Dublin to Cork Railway Line (Elimination and Upgrade) of Level Crossings between Limerick Junction and Mallow Order 2021.

Case Number NA04.310286

Please accept the following observations on the plans for level crossing 212 at Ballycoskery (Ballyhea Village), Charleville Co. Cork.

Figure 2.11: XC212 Ballycoskery Proposed Alignment

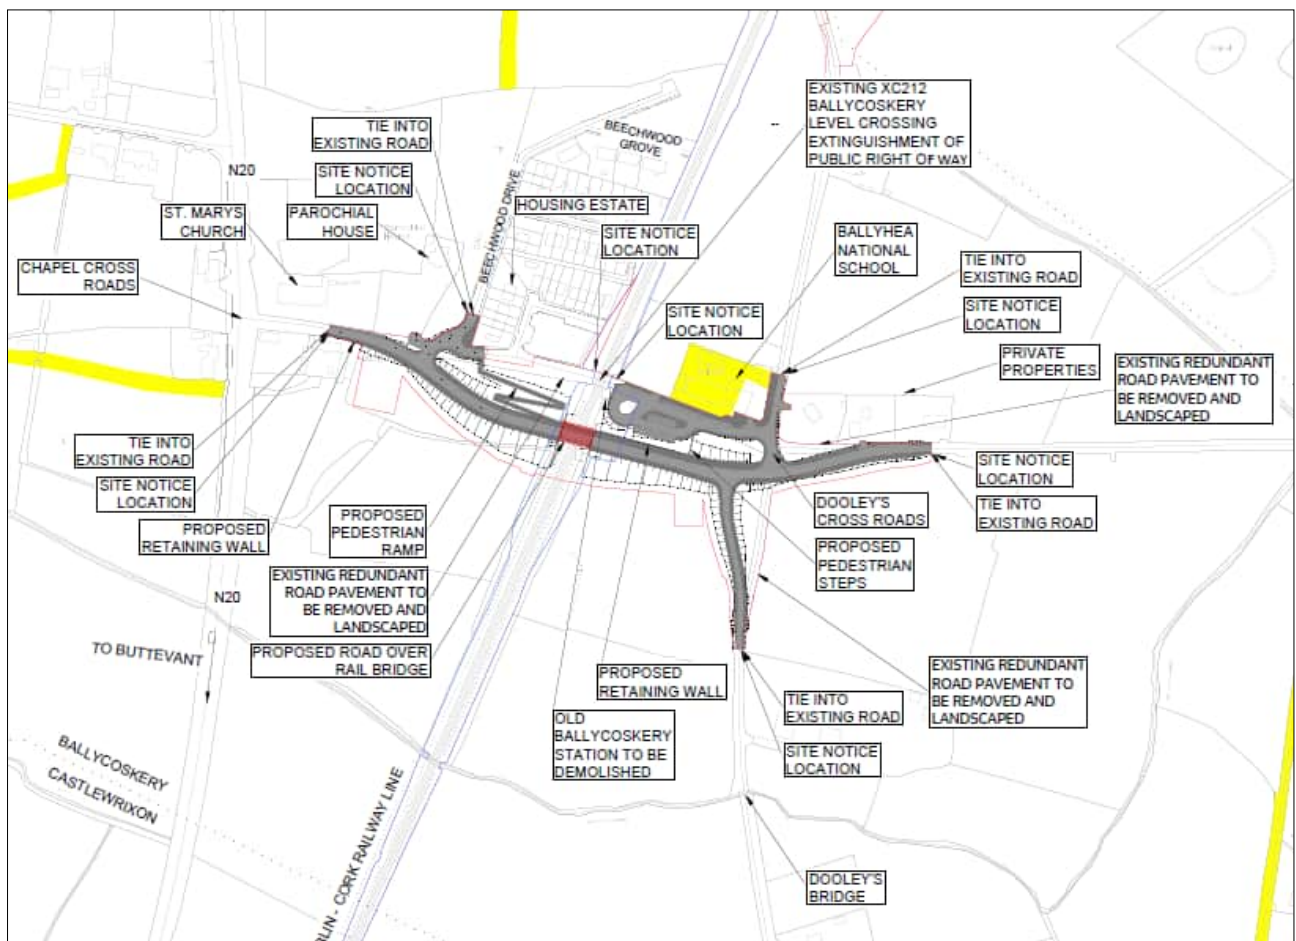
2. The car park in front of the school will be a white elephant as far as the community is concerned. It reduces the green area within the village boundary and more than doubles the area of ground already under asphalt in the school yards. This car park will serve no useful purpose. It is too far from the bus stops on the N20 for those who use the bus services. It is too far for those who car share going to work on the N20. Both of these groups use the church car park on the N20. On the other hand, a car park located in front of the school in a relatively secluded place will give rise to anti-social behavior including halting and camping sites, and drug related activities. I would encourage Bord Pleanala to deny permission for this car-park proposal.

3. The bridge itself is out of all proportion to the size and needs of the village and will become a dominating and ugly sight in the environment. It makes access between the East side of the village and shop and church much more difficult and complicated if using a car. As for the pedestrian bridge attached to the main bridge, this is too long, too complicated and too steep to use. I am over 80 years of age and would be unable to use the foot bridge. In bad weather no one could use it. It is also unusable for anyone in a wheelchair. It makes access to the community hall much more difficult especially for older people. Over ten years ago I proposed that an underpass be built if CIE wanted to close the railway gates. Little consideration was given to that option. Apart from leaving the level crossing as it is or automating it, I still think that the best proportionate solution to the level crossing at Ballycosgery is an underpass. Nobody would object to that solution. The height of the underpass can be kept reasonably low by diverting heavy goods traffic to other crossings along the rail line. In fact, CIE only recently completed an underpass for a local farmer not 200 meters from the Ballycosgery level crossing. If it was possible 200 meters from Ballycosgery it should be possible at Ballycosgery. If it were necessary to install a pumping system for an underpass (although the gate is not within the flood zone), this is already present at the Ballycosgery gates and is used by the housing estate. It should be possible to connect to this pumping station and, if necessary, install a parallel pipe line to carry
